CITY OF ALBUQUERQUE

November 22, 2016

Re: Betos Boots
5901 Rio Vista Dr. SW
60-Day Temporary Certificate of Occupancy- Transportation Development
Engineer's Stamp dated 07-19-16 (L11D068)
Certification dated 11-21-16

Clark Consulting Engineers 19 Ryan Road Edgewood, New Mexico 87015 Tele: (505) 281-2444 Cell: (505) 264-8042	
DATE	REVISION
6/15/16	ADD. TCL COM'TS.
7/8/16	ADD. (2) TCL
7/19/16	
DESIGNED BY: PWC CHECKED BY: PWC	
DRAWN BY: CCE DATE: 12/23/15	
JOB# BURK_RioVista FILE #: TCL	
1 OF 1

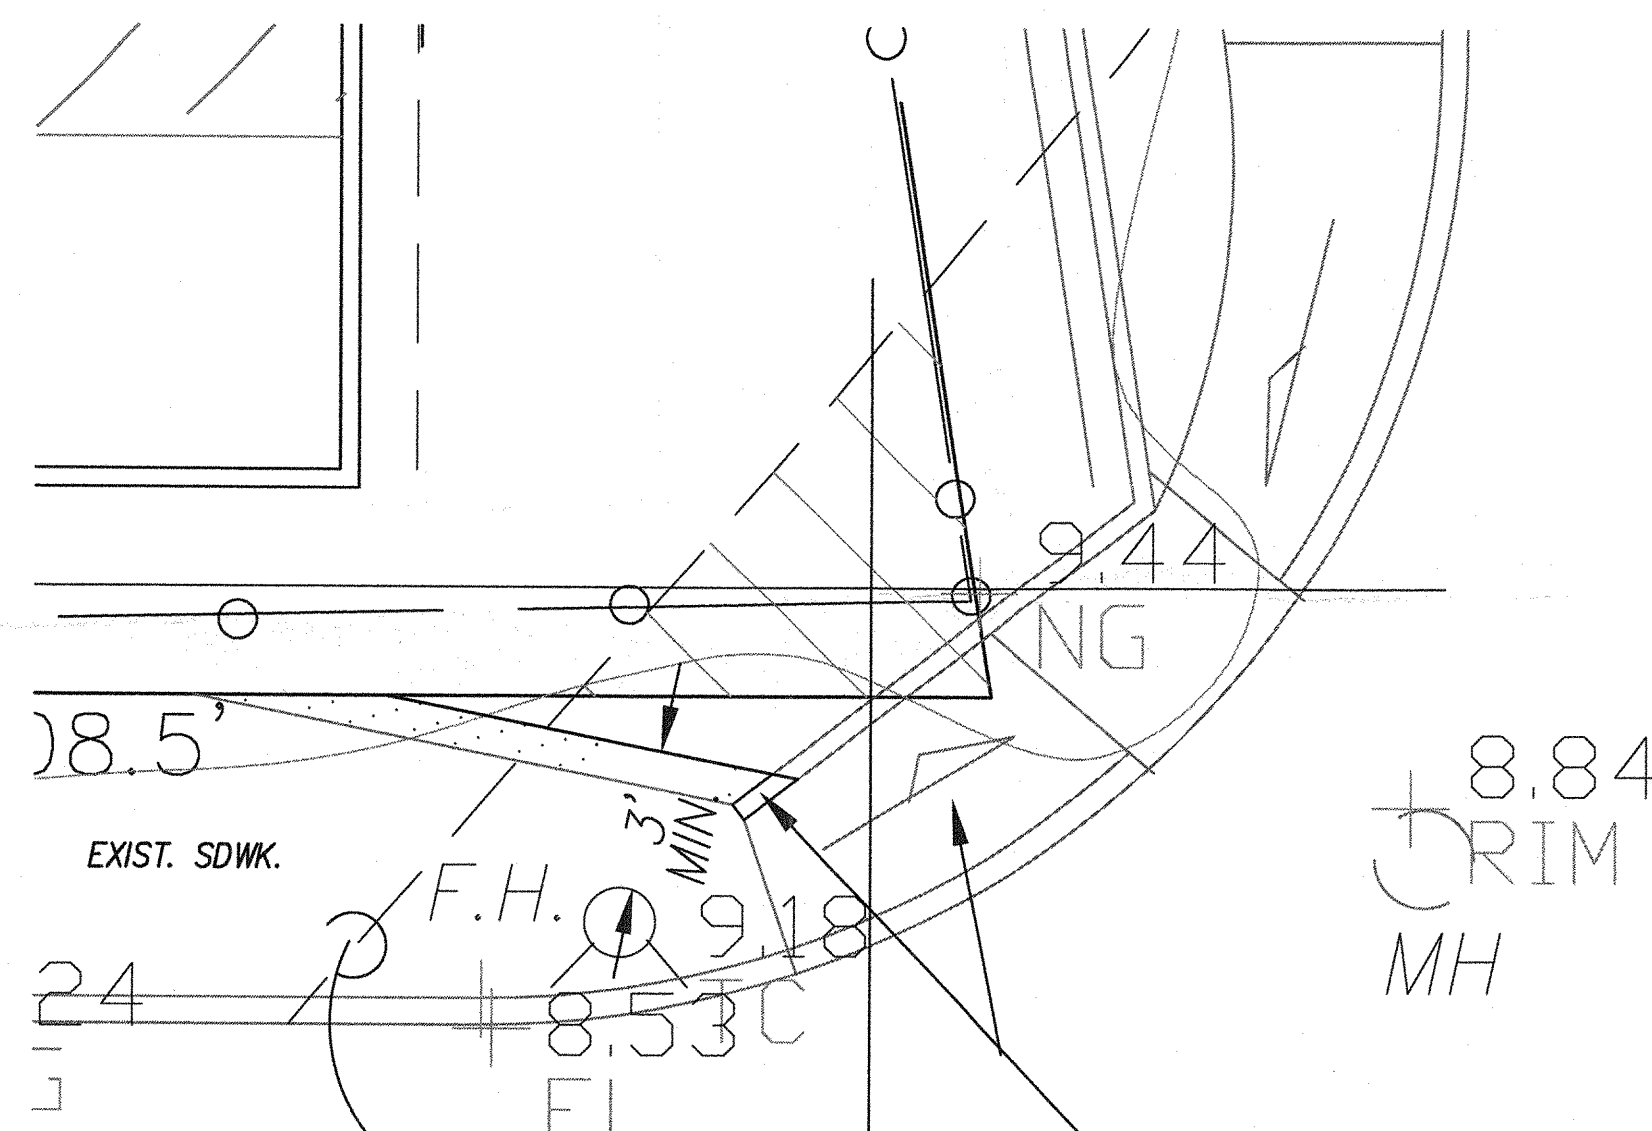
1. The ADA accessible parking sign must have the required language per 66-7-352.4C NMSA 1978 **"Violators Are Subject to a Fine and/or Towing."** Please call out detail and location of HC signs.

2. The ADA access aisles shall have the words **"NO PARKING"** in capital letters, each of which shall be at least one foot high and at least two inches wide, placed at the rear of the parking space so as to be close to where an adjacent vehicle's rear tire would be placed. (66-1-4.1.B NMSA 1978)

3. The drive pad located at the southwest corner of the property will need to be closed and replaced with sidewalk, curb and gutter. As called out on the approved TCL.
